Statement of Common Ground with Beverley and North Holderness Internal Drainage Board (draft)

Revision 2

September 2025

- 1.1.2 The DCO Application is for a Nationally Significant Infrastructure Project (NSIP) for the construction, operation (including maintenance) and decommissioning of a solar photovoltaic (PV) array electricity generating facility, Battery Energy Storage System (BESS) and associated infrastructure which would allow for the generation and export of electricity.

**Typical DC trench
roadway/crossing points**

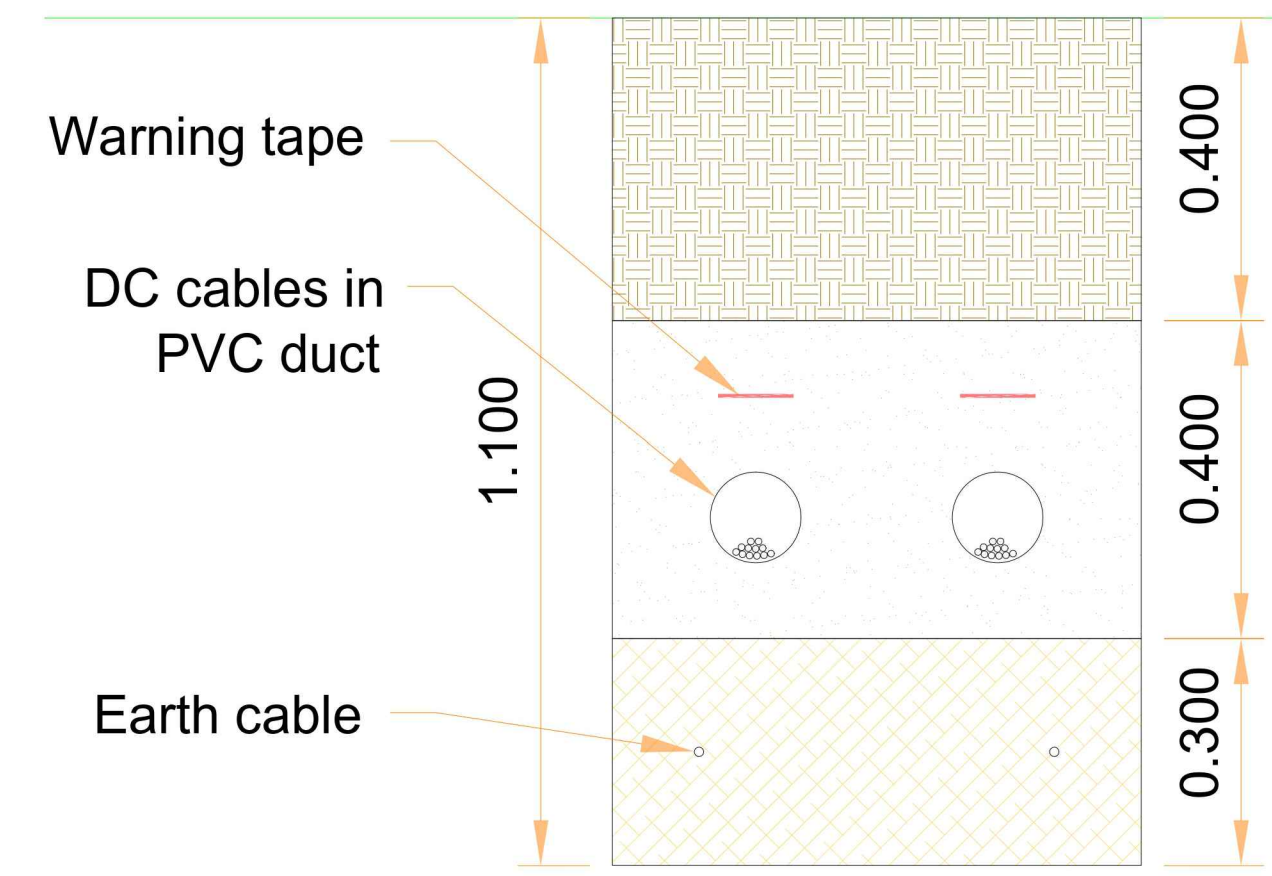
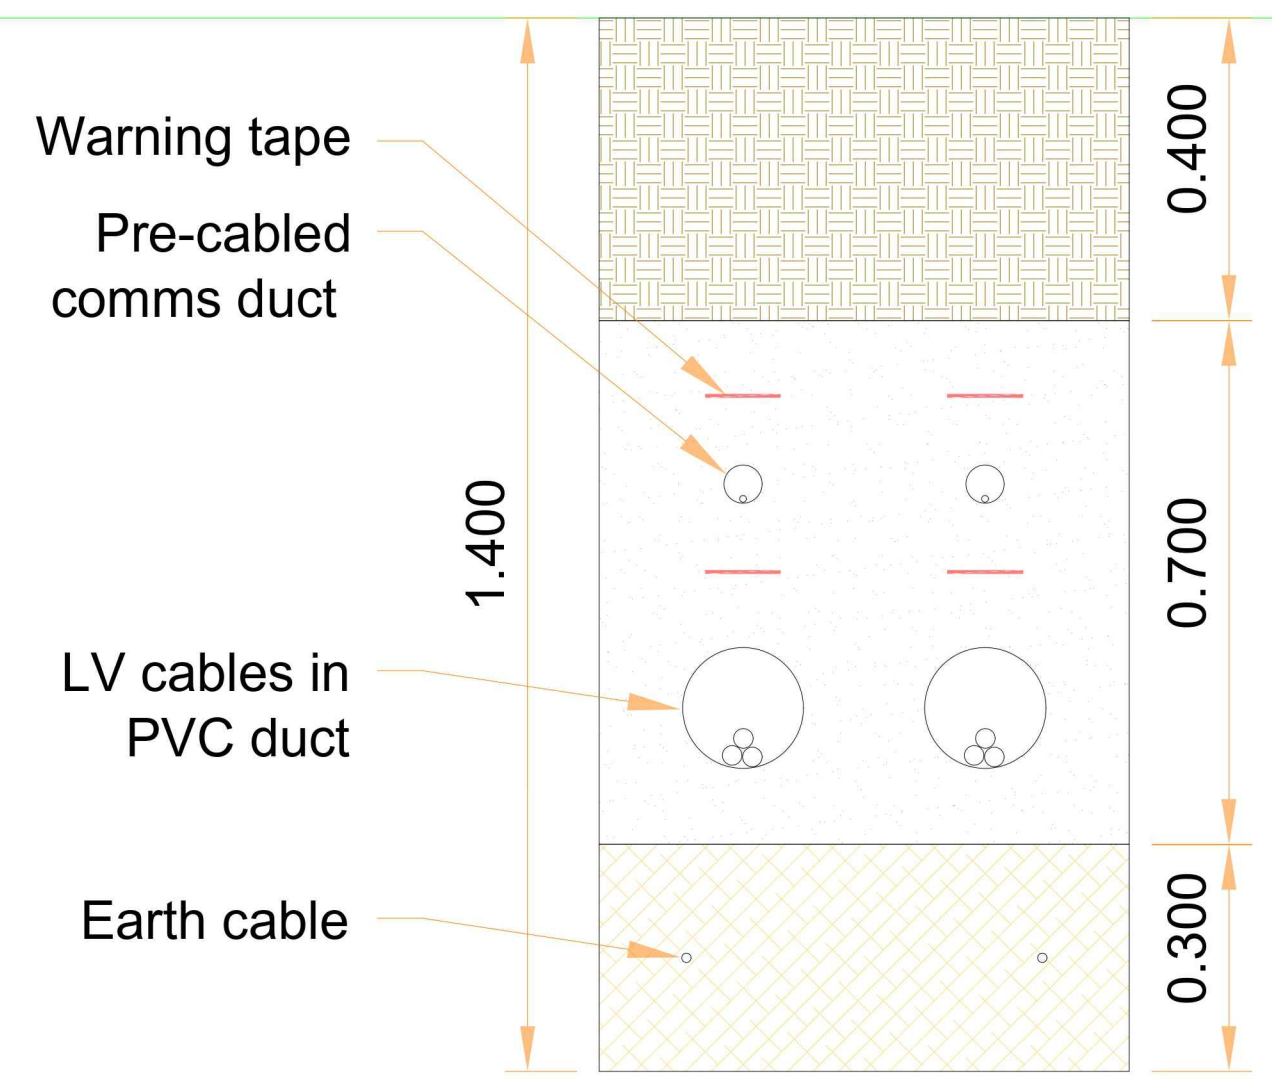
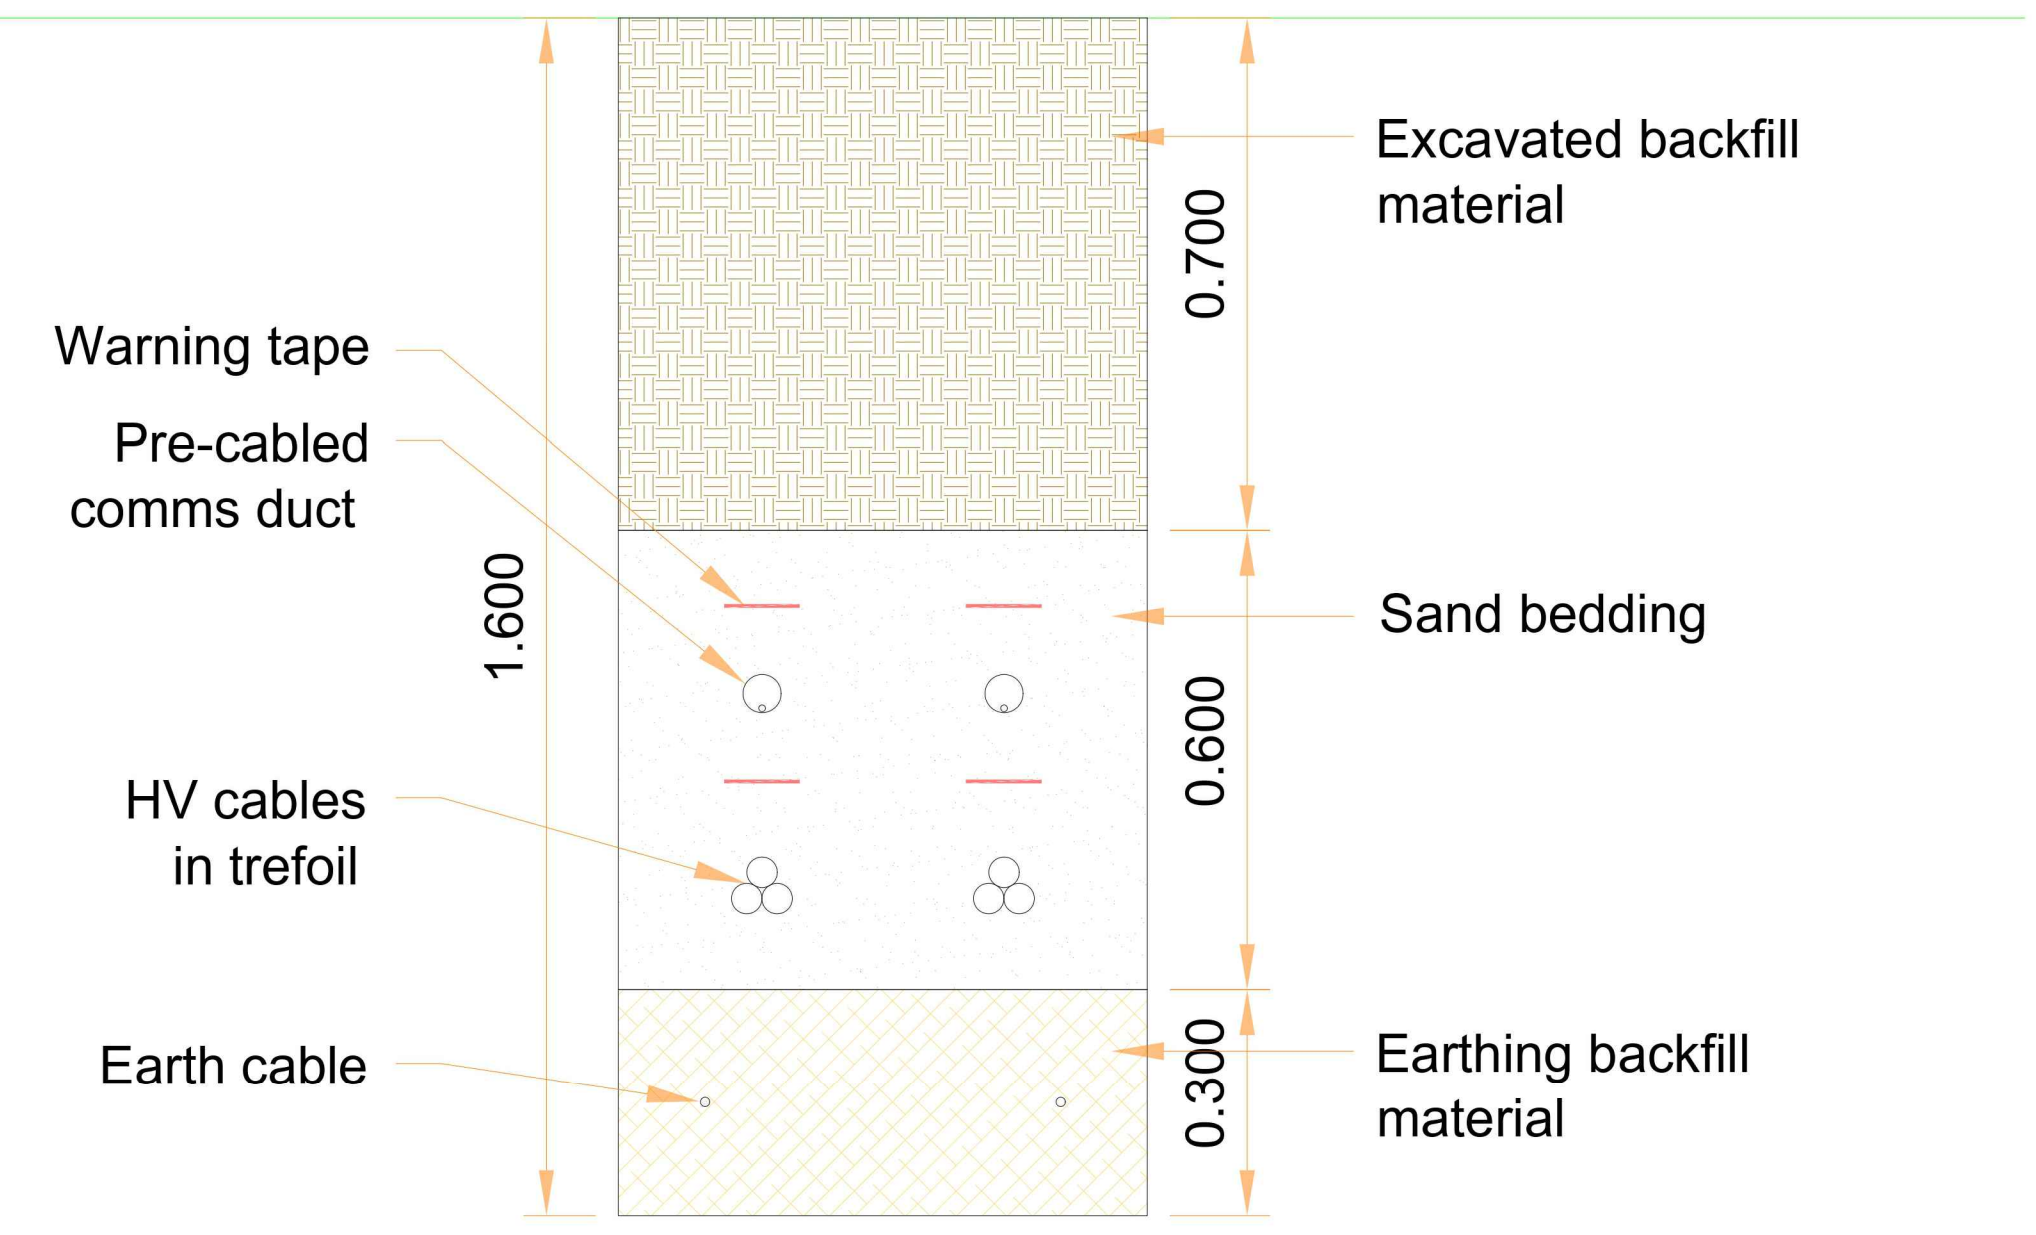
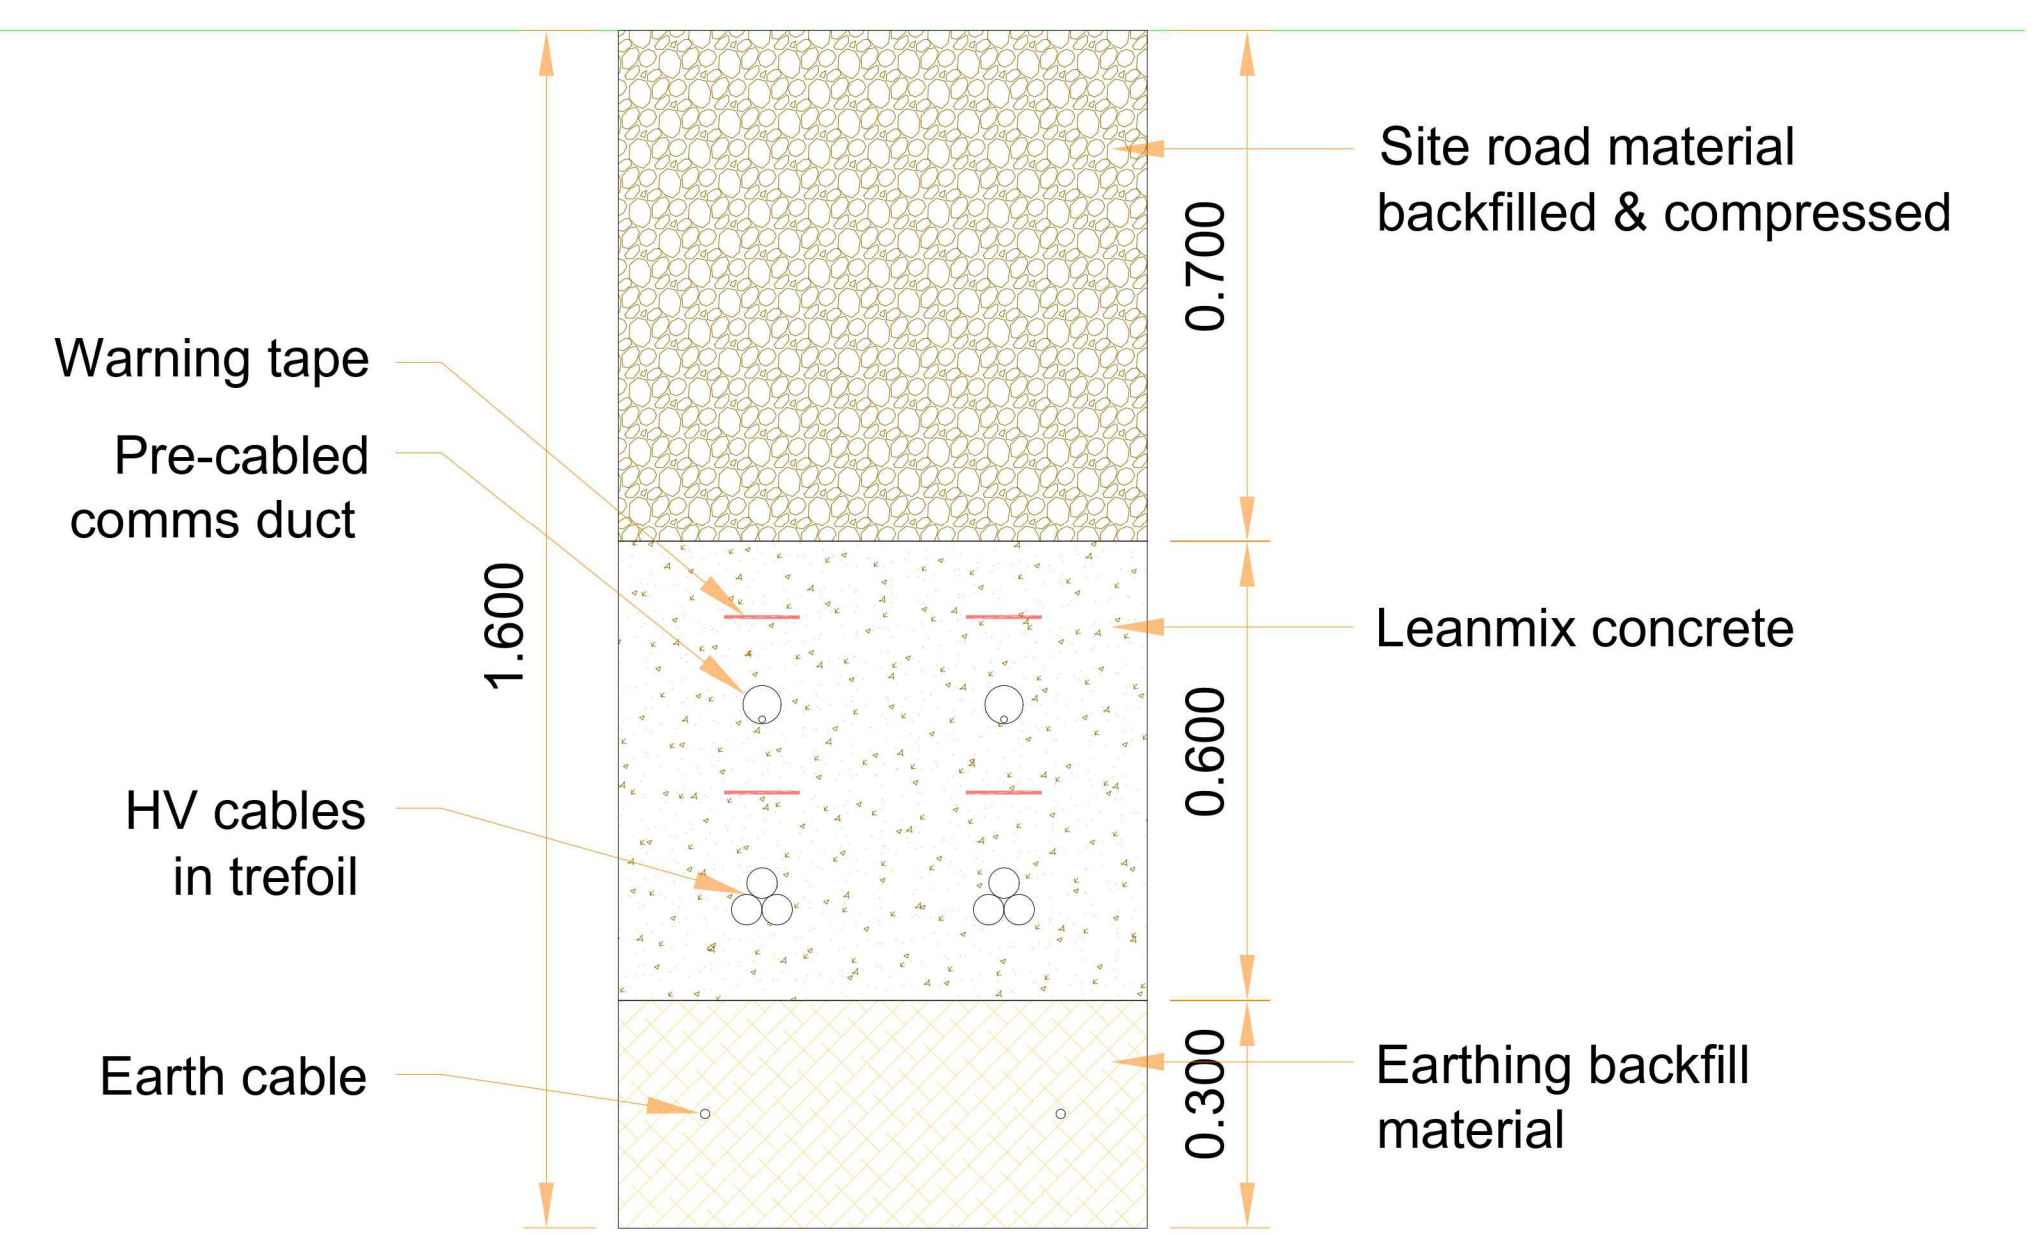
IDB04	Cables	In its relevant representation [RR-004] , Beverley and North Holderness Internal Drainage Board requests that the Applicant seek prior written consent	The Applicant agrees to this request. As set out in the Outline Construction Environmental Management Plan [EN010157/APP/7.2 Revision 2] the Applicant proposes to use	Under discussion

Ref	Topic	Beverley and North Holderness Internal Drainage Board Position	Applicant's Position	Status
	<i>Hydrology and Flood Risk</i>	from the Board if proposing to insert a cable under a watercourse within the Board's district. The Board would prefer for any cables crossing watercourses to be laid above any existing culverts so that they do not affect water flows and do not therefore require the Board's consent in terms of the cables themselves. If this is not feasible, directional drilling must be used. The Board will not accept open cut crossings.	horizontal directional drilling (HDD) or crossings above watercourses. The Applicant is not proposing to use open cut methods to cross Board-maintained watercourses. The Applicant notes the need to seek written approval from the Board prior to installing cables over or HDD-ing under watercourses within the Board's district and this is secured in the protective provisions for the benefit of the Board set out in the Draft DCO [EN010157/APP/3.1 Revision 4] .
